# V1\_Drainage Report - Final\_Comments.pdf Markup Summary

PCD File No. SF-2239

DETENTION/WATER QUALITY FACILITY
1"=30'

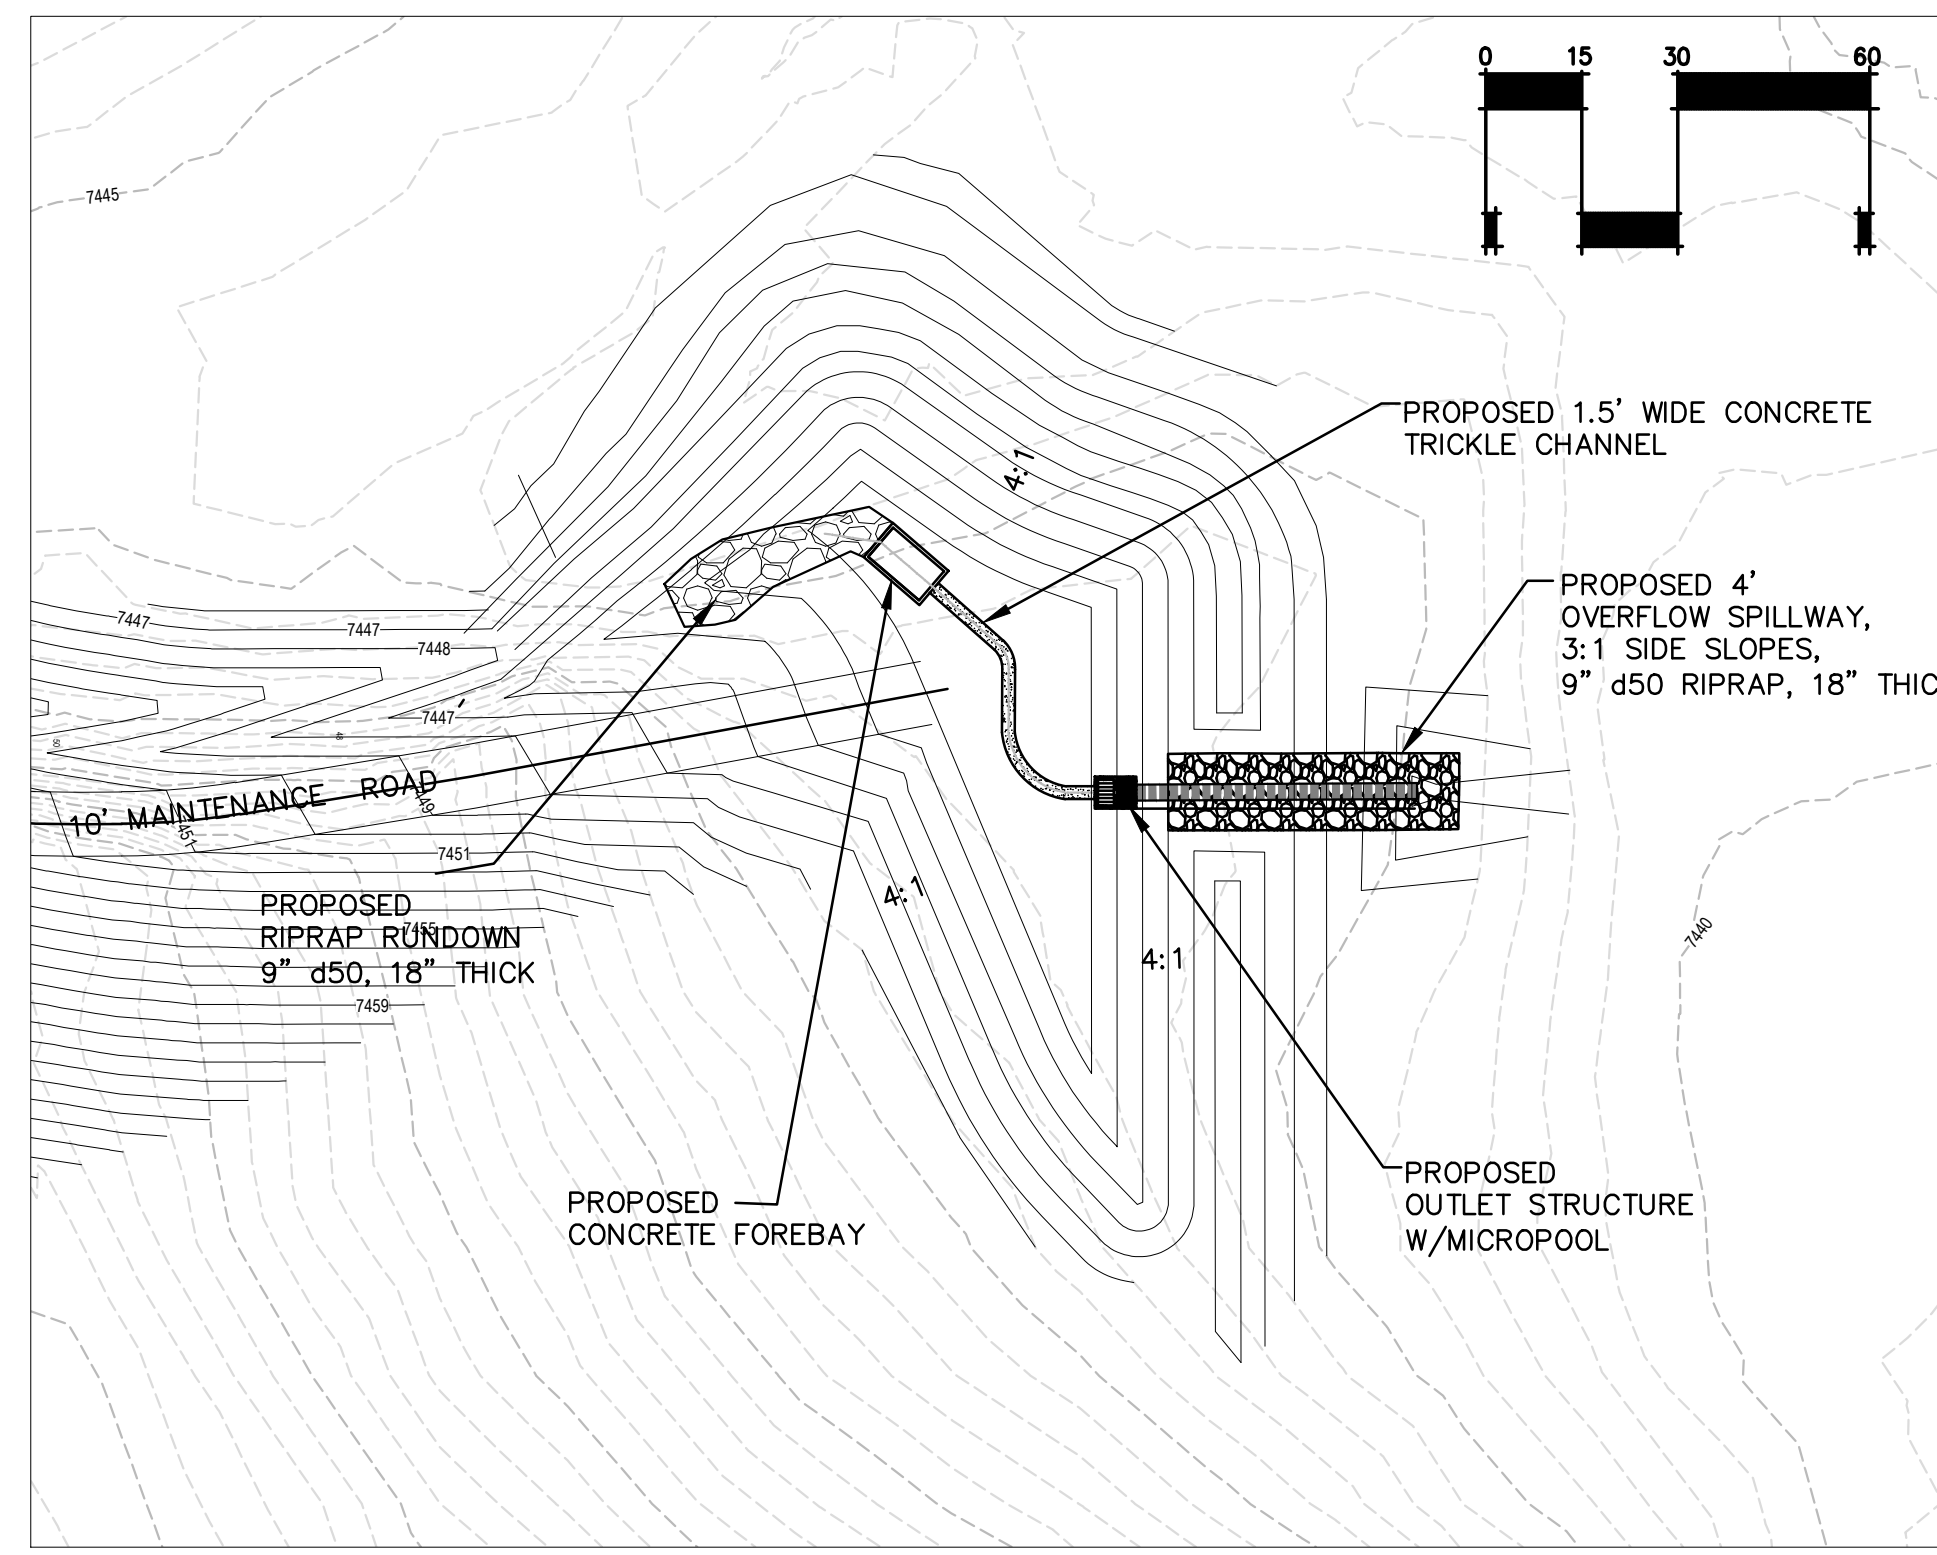
provide Hec-RAS channel hydraulic analysis to determine if improvements such as bank armoring at the bends are required.

Two culverts are addressed in the previous narrative. Revise to remove inconsistencies. Also remove culvert analysis reports for culverts that are not being proposed.

Add a column that identifies the contributing basins and design point for the cumulative flows.

provide outlet protection calculation to the 24" and 18" RCP. Update the CDs if outlet protection is required.

Add dark linestyle to legend. If it is just delineating basins keep linestyle consistent.

Label entrance types on culverts per culvert reports attached.

Provide a detail for the spillway that shows cross section.

Show time of concentration paths on drainage maps.

Provide contour labels.
